Application for non-material amendment to Planning Permission 2024/62/91998/W

“Erection of special educational needs and disabilities school (use class F1), comprising educational buildings, roof mounted photo-voltaic panels, sensory garden spaces, multi-use games areas, landscaping, hardstanding areas, carparking, access with secure fencing and associated ancillary development”

Specifically, this application proposes non material amendment to drawings referenced in condition 2 (Plans and Specifications Schedule), condition 20 (lighting) and Condition 22 (Drainage).

TITLE
EXTERNAL LIGHTING SHEET 2 OF 2

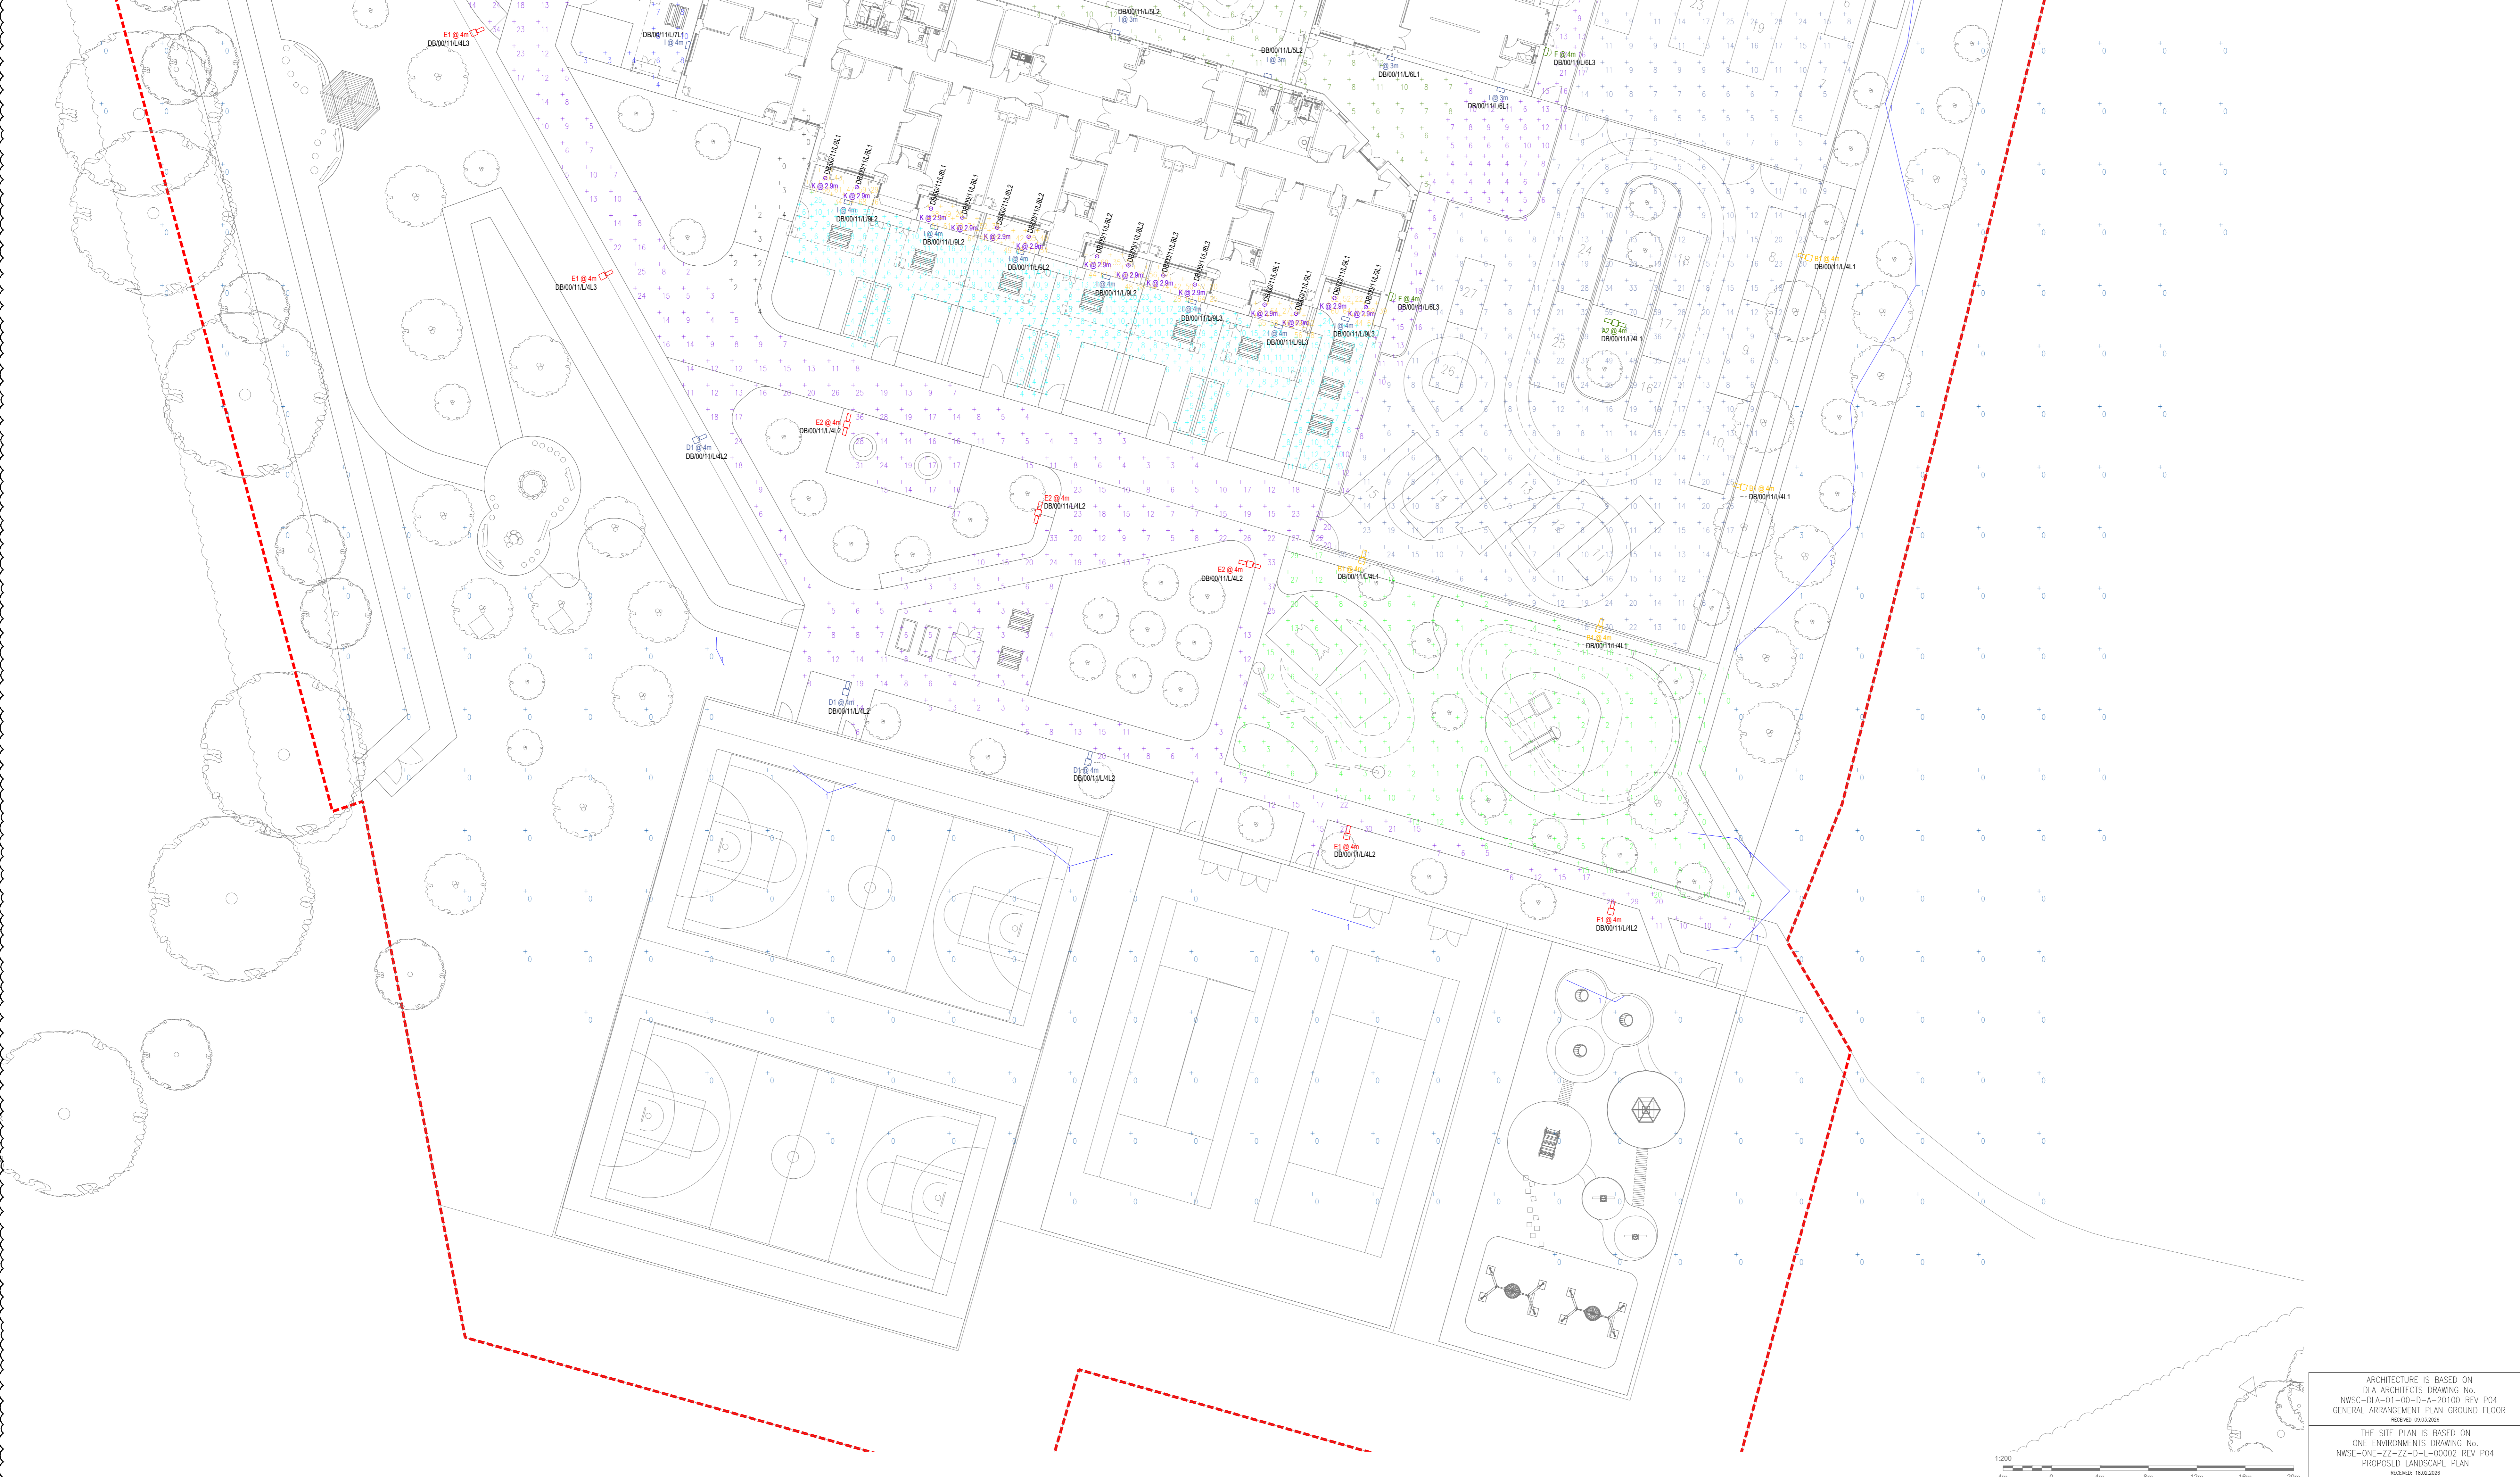
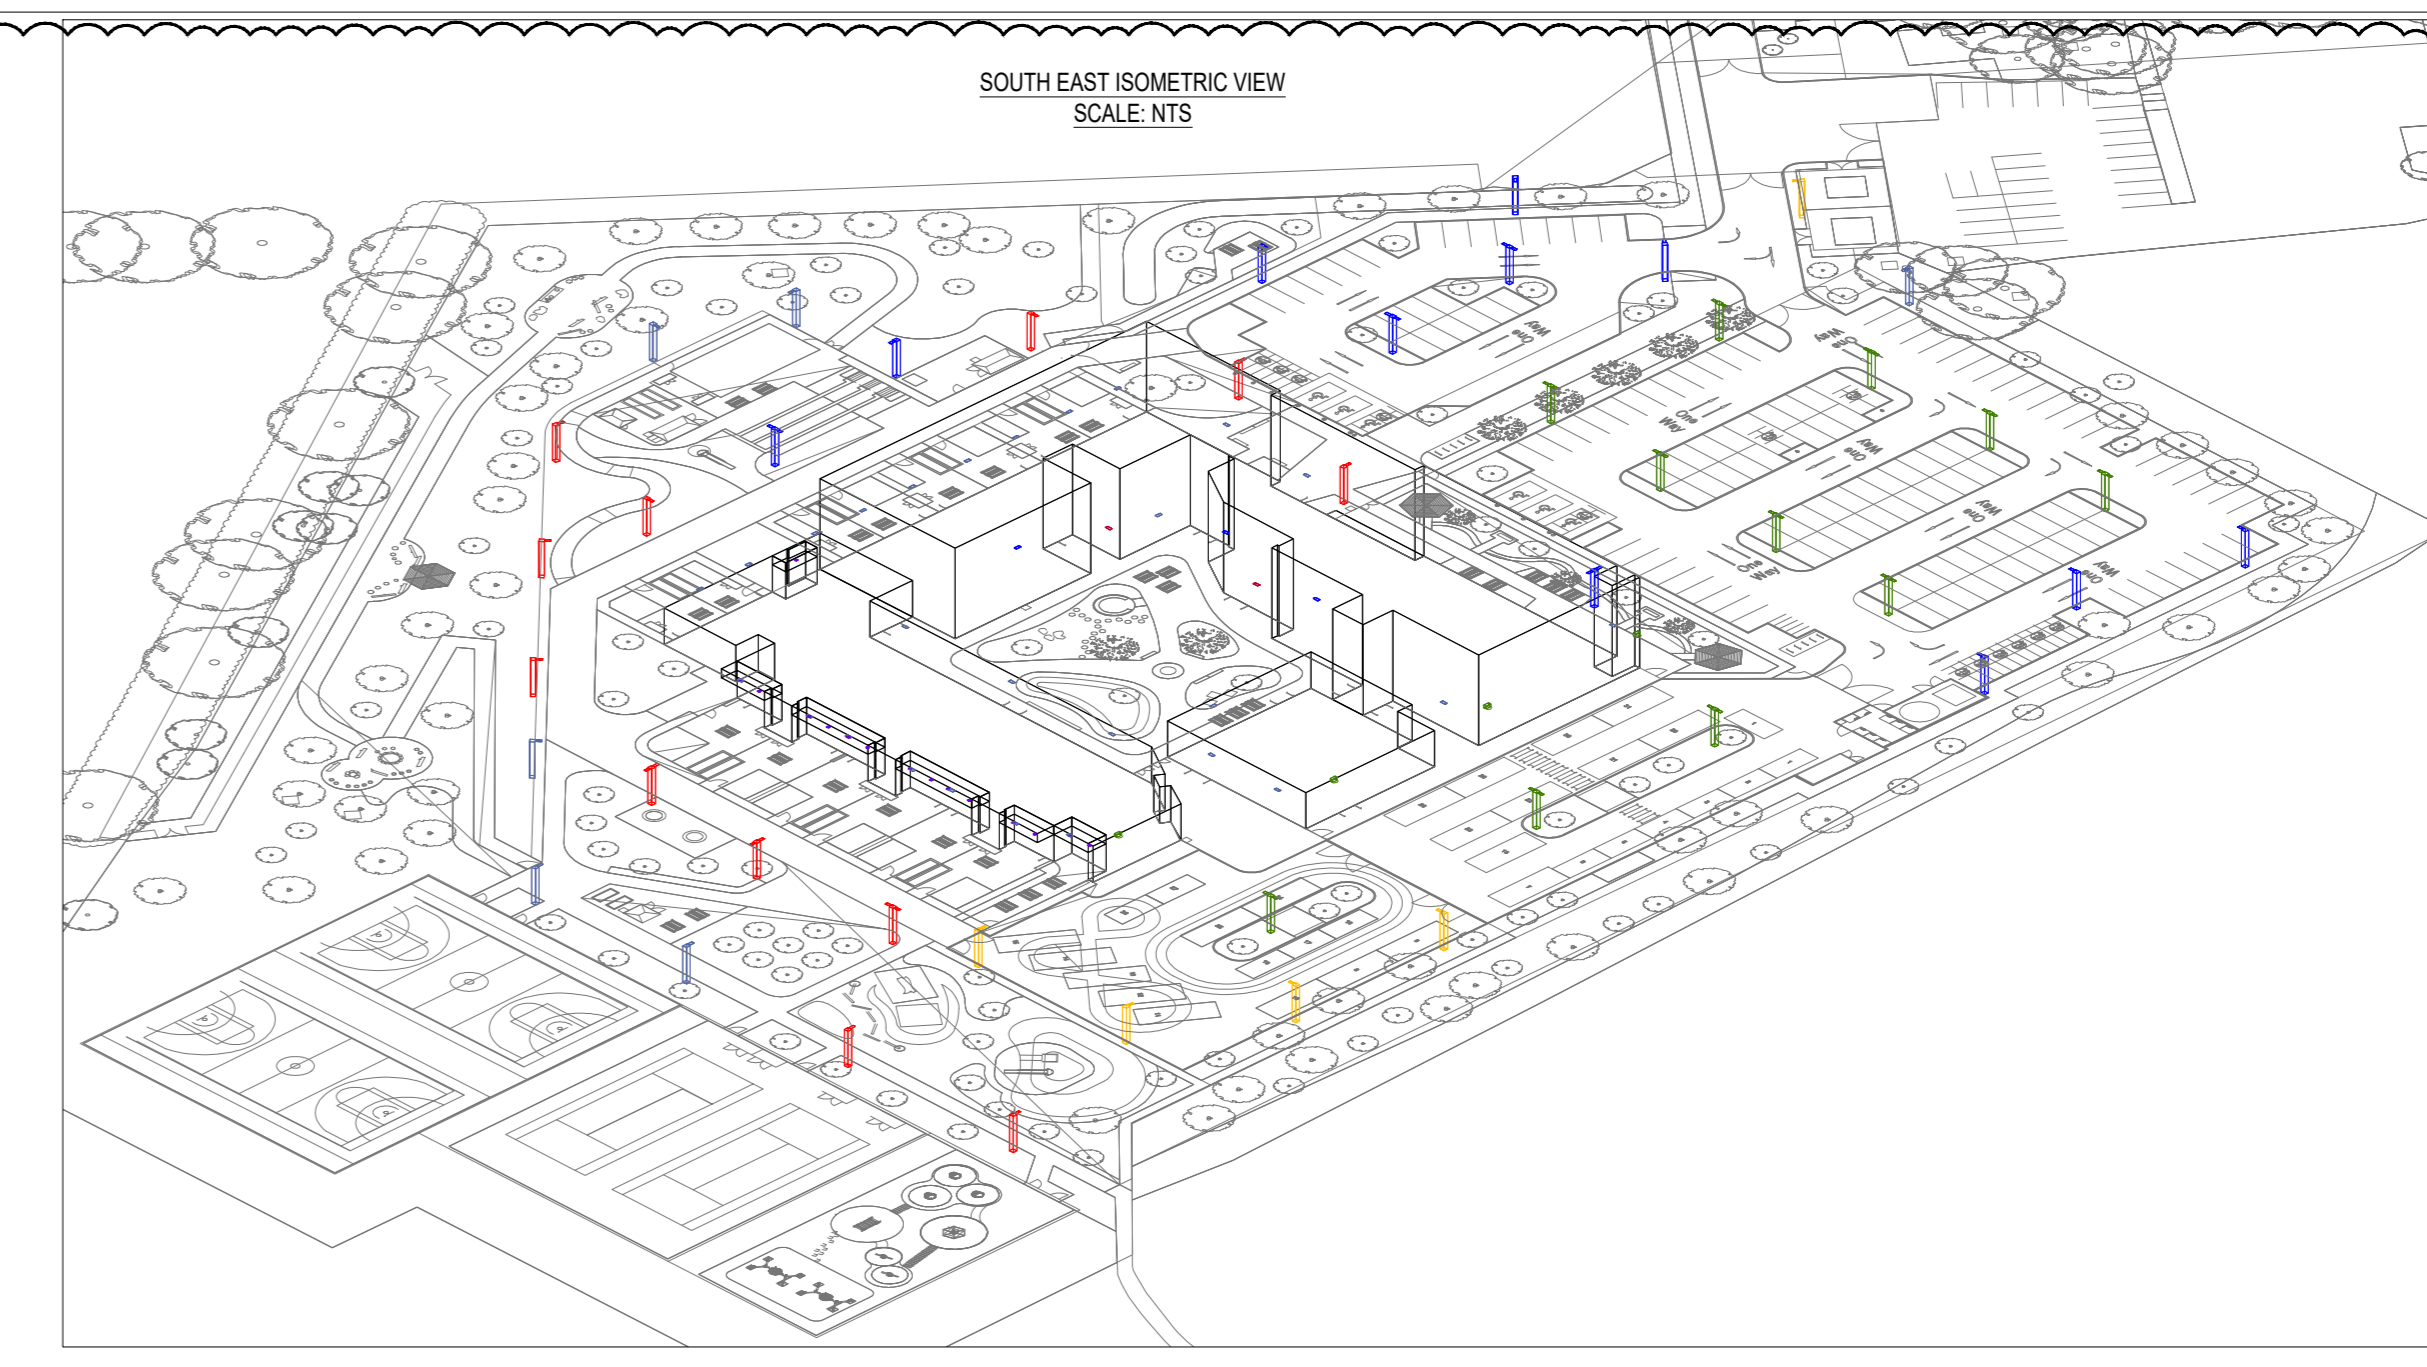
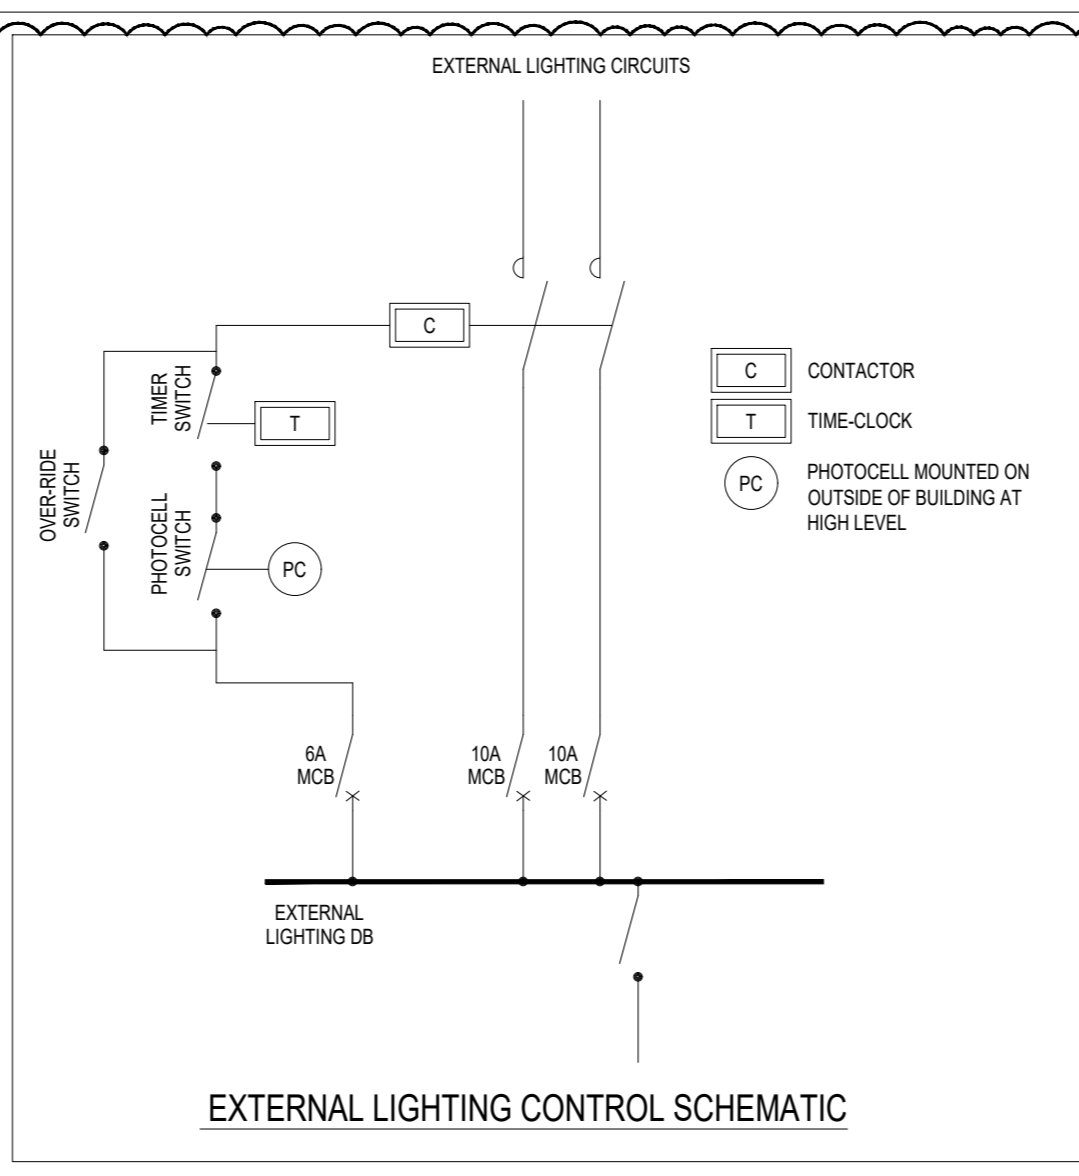
Whilst the specification of the lighting remains unchanged, an updated lighting drawing has been prepared to reflect non material changes following Stage 4 Design.

*“The external artificial lighting for the play area shown on hereby approved drawing nos. **NWSC-GAH-00-00-D-E-01101-External Lighting Sheet 1 of 2-S3-P03** & **NWSC-GAH-00-00-D-E-01102-External Lighting Sheet 2 of 2-S3-P03**, and any external lighting erected for the MUGAs, shall only be operated between -*
